Our ref: PS124347-GEO-LTR-001_final

Review of Geotechnical Report - Proposed Residential Development, 89 John Whiteway Drive, Gosford, NSW

At the request of the Department of Planning, Industry and Environment (DPIE), WSP Australia Pty Ltd (WSP) has provided geotechnical peer review services for the proposed Residential Development at 89 John Whiteway Drive, Gosford, NSW. We understand that the development is located in a former quarry and a key concern has to do with the stability of the excavated rock cuttings along the northern and western margins of the development.

Project Number	Drawing Number	Rev
19002	DA002.1	16
Coordinator : Approver	Checked : Checker	
Scale: As indicated @ A1	Date Printed: 2021-07-26 3:16:28 PM	
File Name:

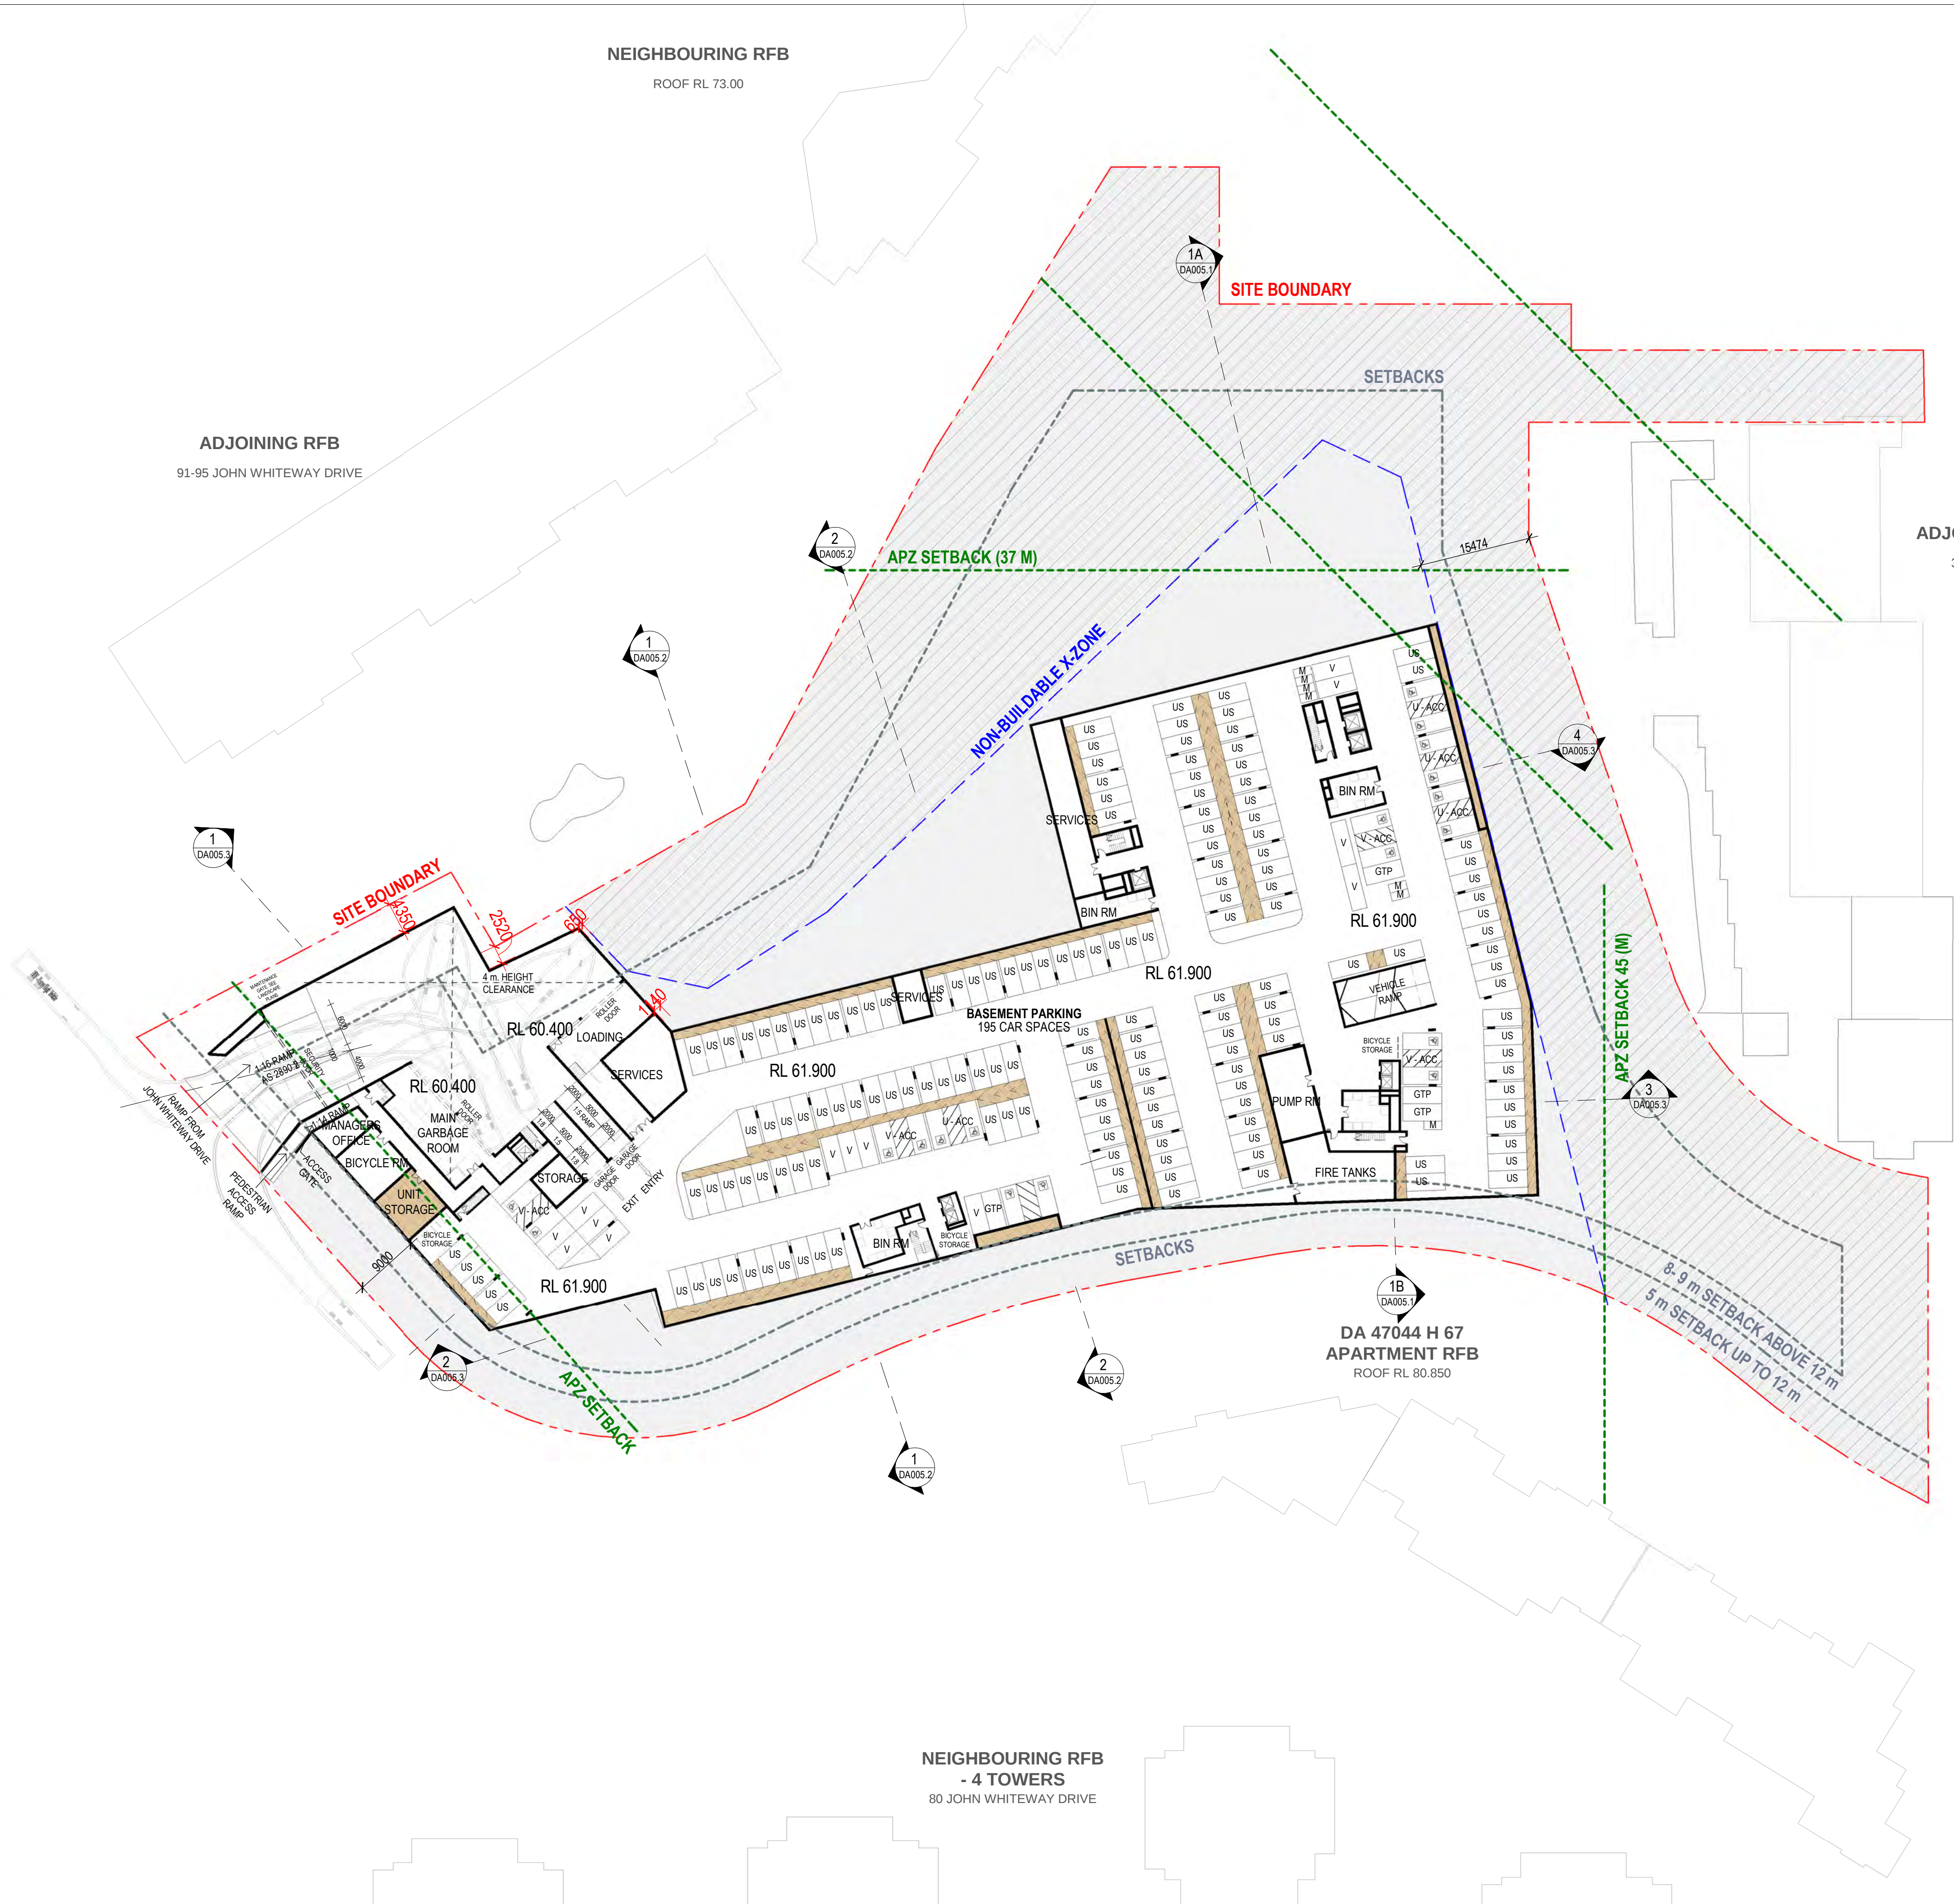
It is noted that slightly deeper excavation is proposed at Block A for vehicle/truck access ramp to the basement from John Whiteway Drive with less than 6 m to the boundary and cliff (Figure 5.1). It is recommended that following actions to be taken to ensure the stability of the cliff at this location

- The design of foundations, if any, should have loads be transferred down to the zone of influence.
- Geotechnical engineer to inspect the exposed rock face to identify any potential rock wedges and advised protection measures.
